Subject: RE: Y/9818/RES and Y/97/18/DOC

Laura Gibbons, MEng, GMICE
Engineer (Drainage & Coastal)

Job Title		
LAND SOUTH OF BURNDELL ROAD, YAPTON		
Drawing Title		
PRIVATE DRAINAGE CONSTRUCTION DETAILS SHEET 1 OF 2		
Client		
BOVIS HOMES		
Scale	Date	Designed
NTS @ A1	APR 19	SG
Drawn	Checked	Approved
TSB	SG	LH
Job No	Drawing No	Rev
18-070	18-070/110	C

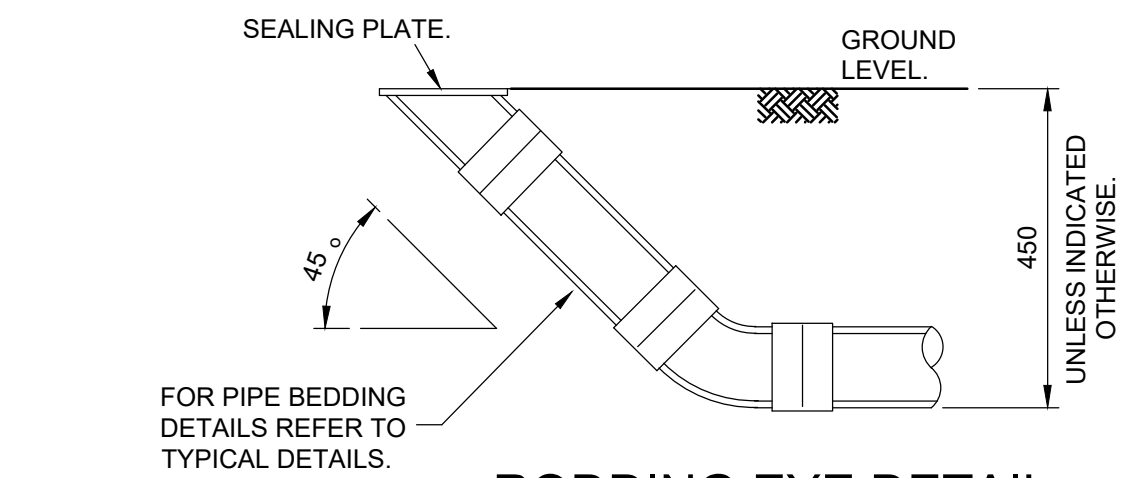
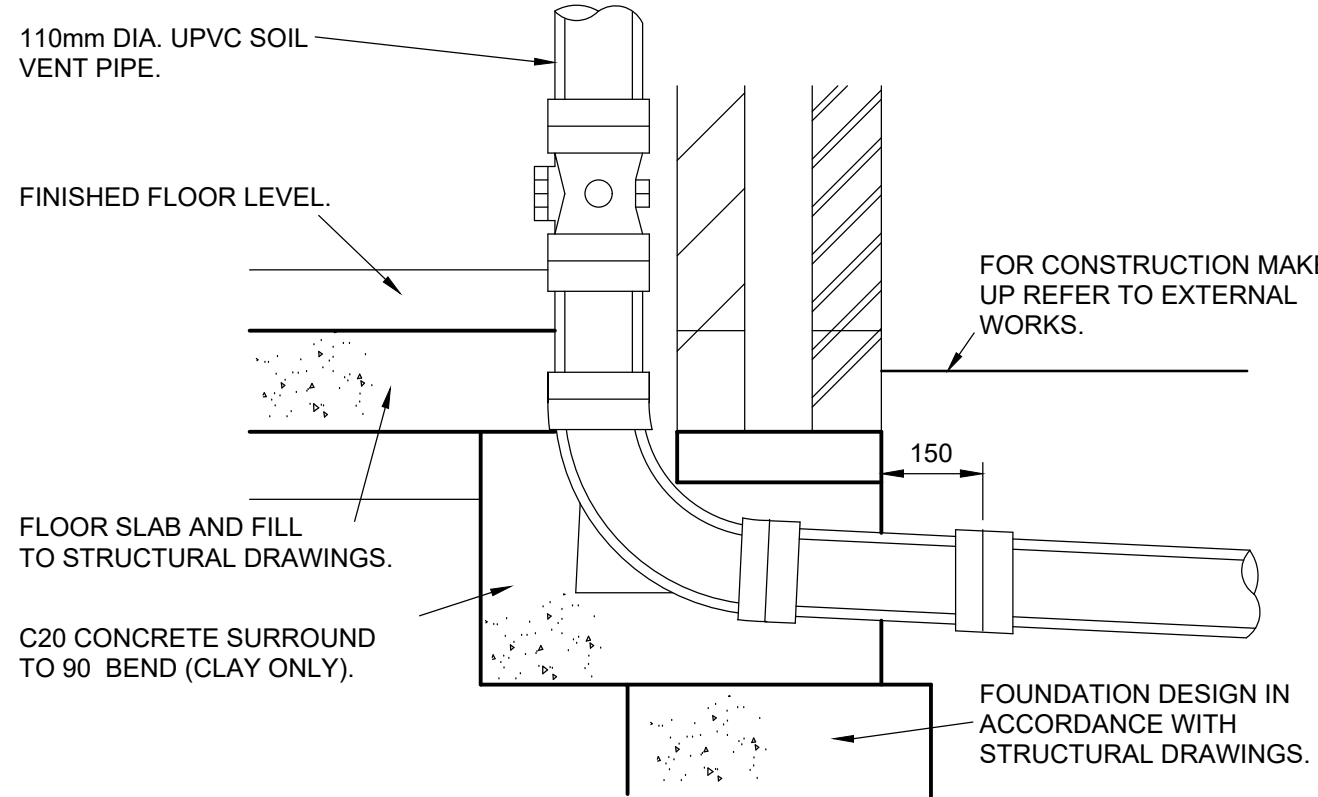
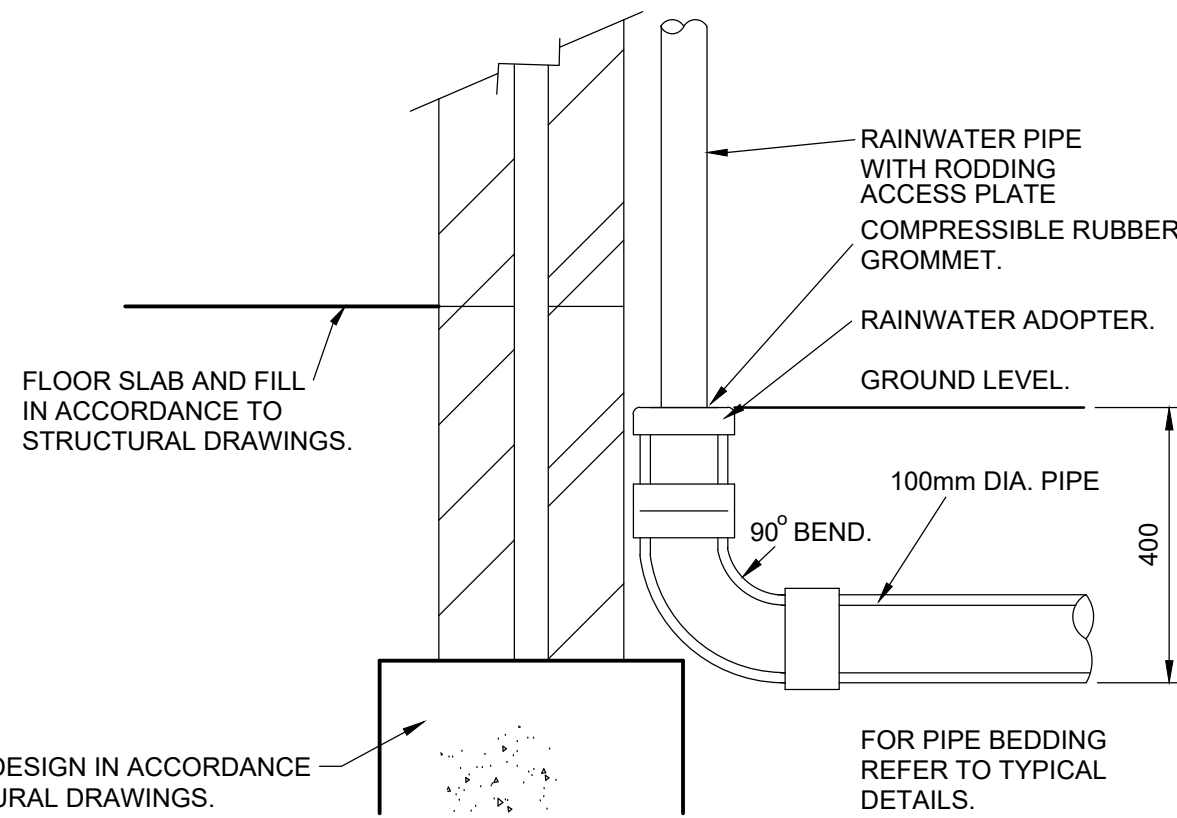
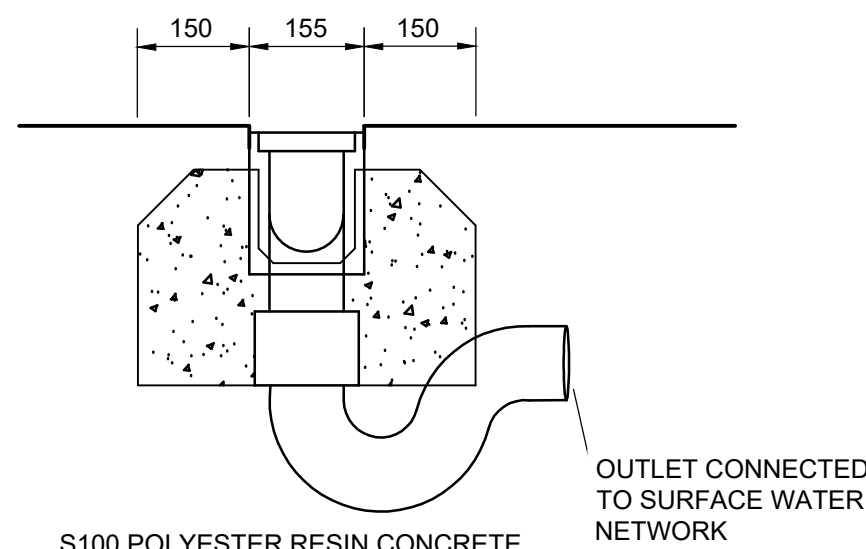
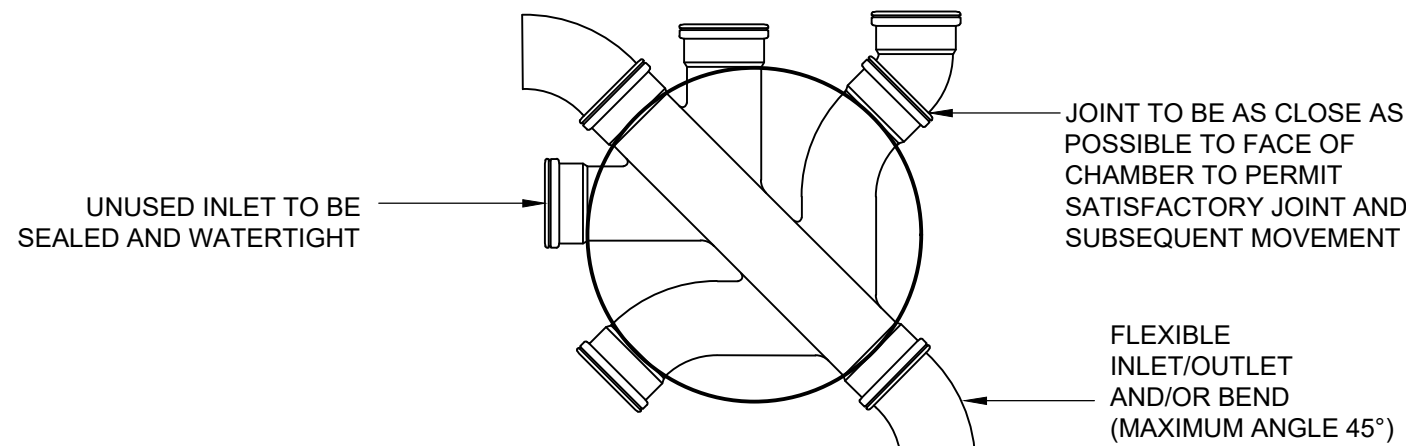
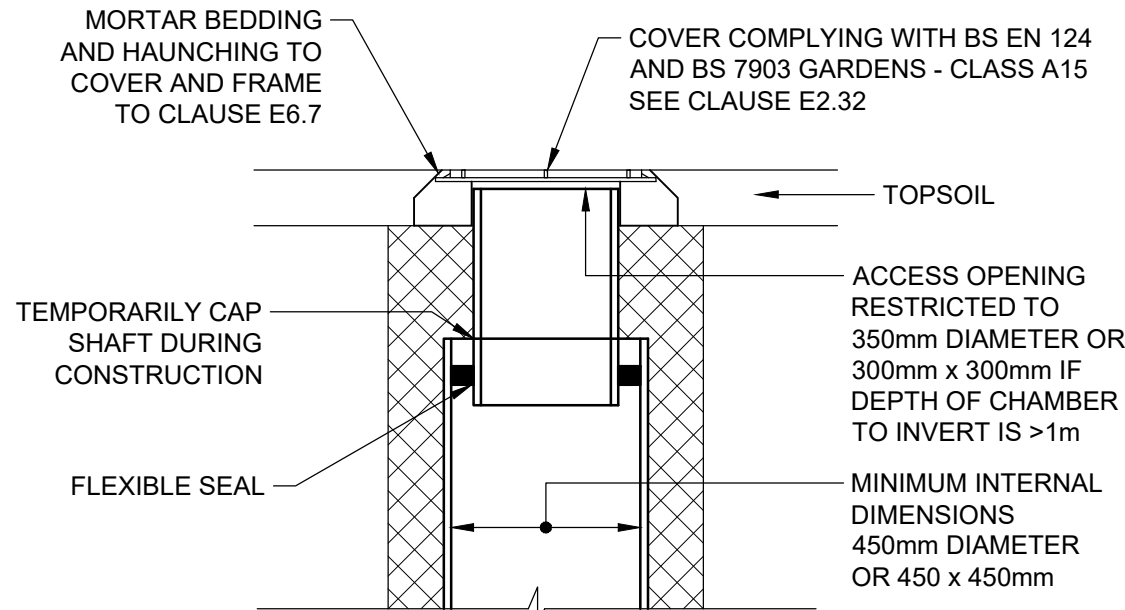
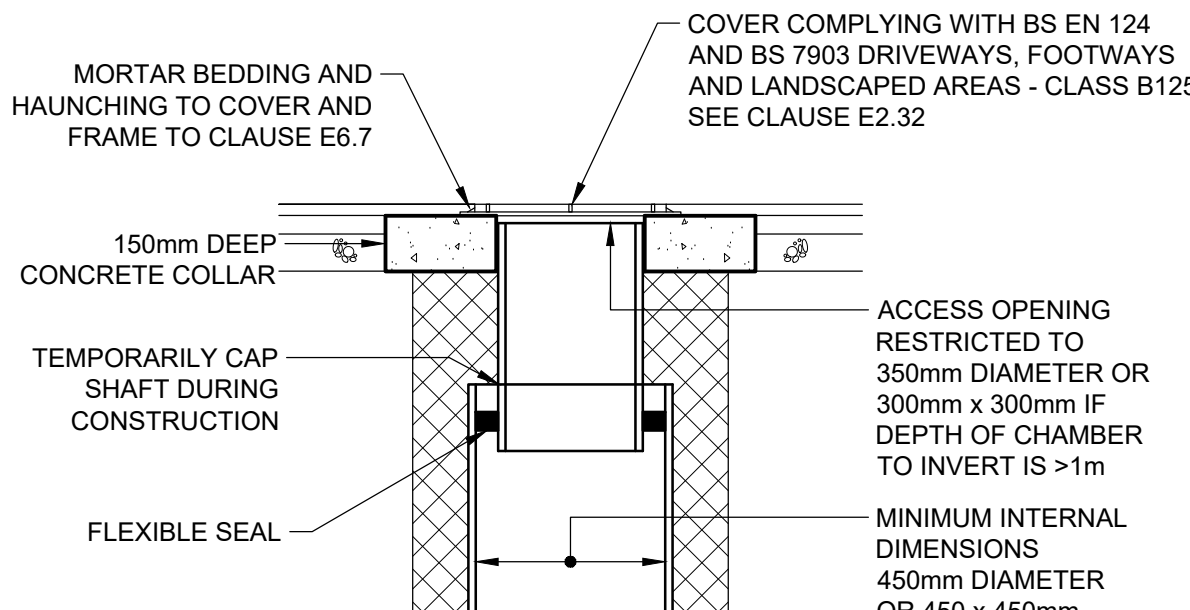
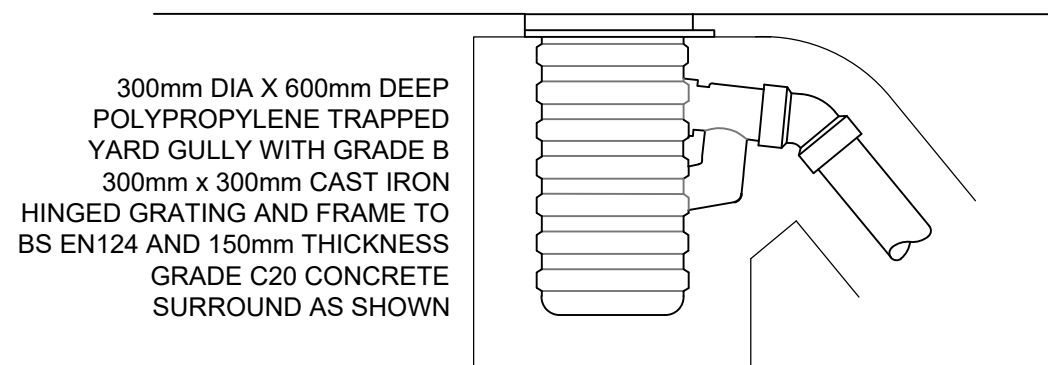
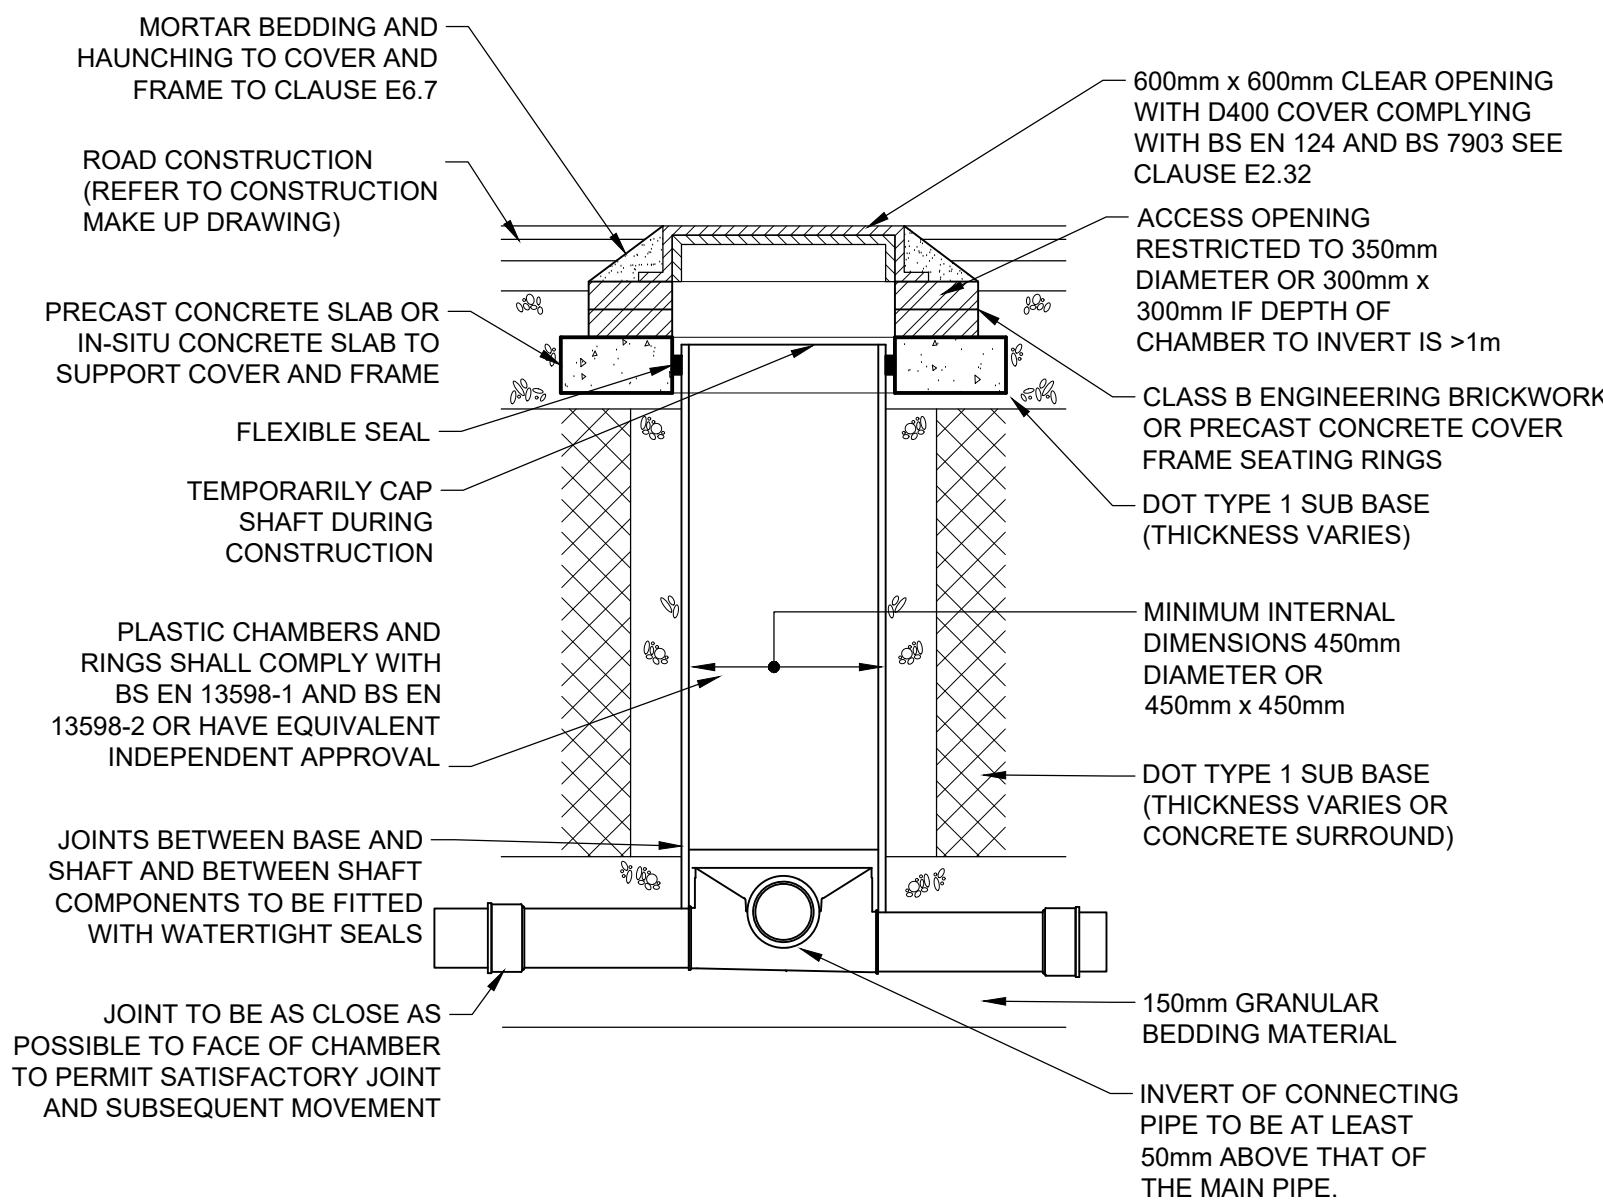
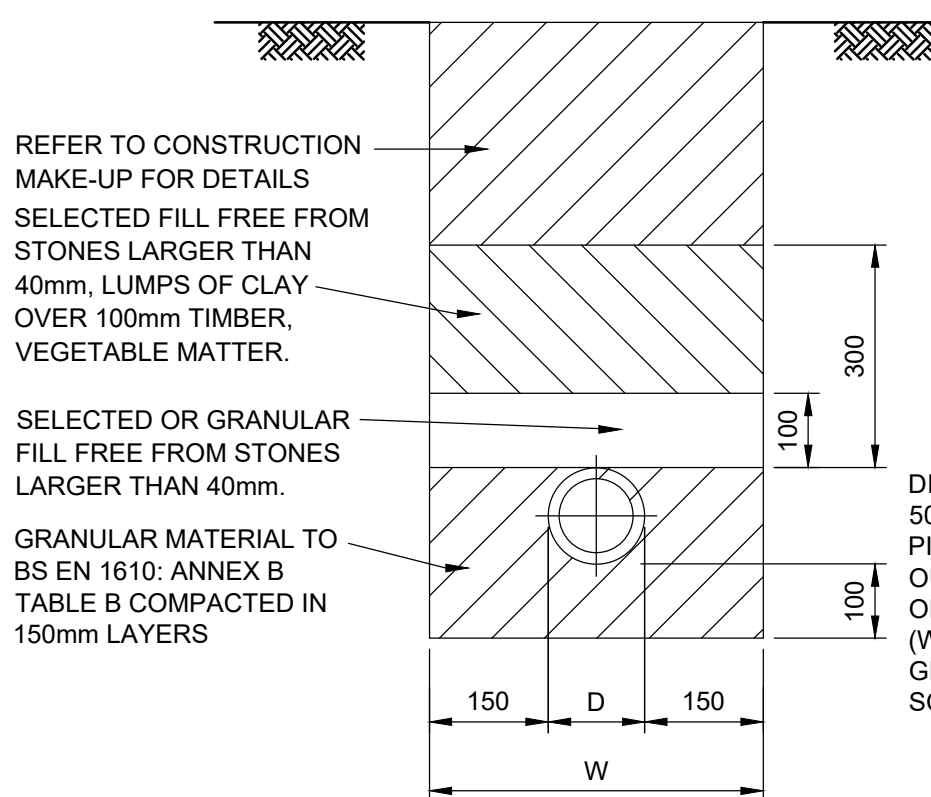
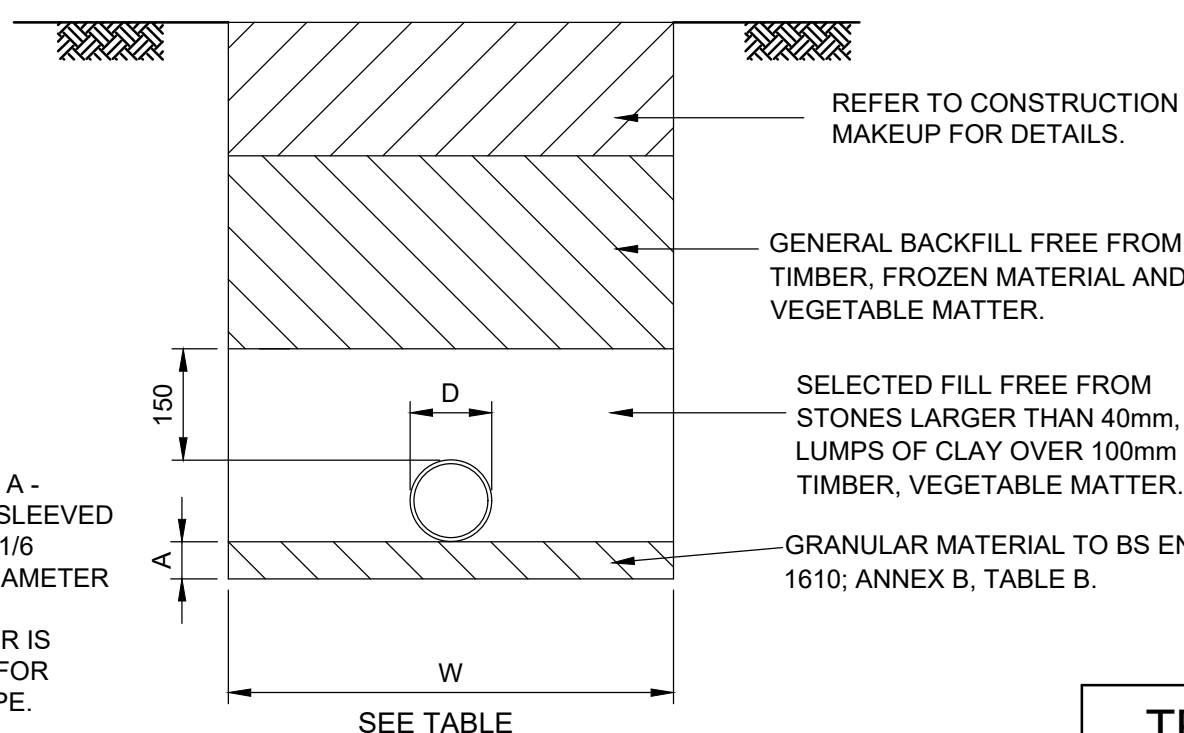
4. There are discrepancies between cover levels and invert levels of tanks in flotation calculations and on drawings.
5. Please update the construction detail drawings to show permeable geotextile wrap fully around the sub-base.
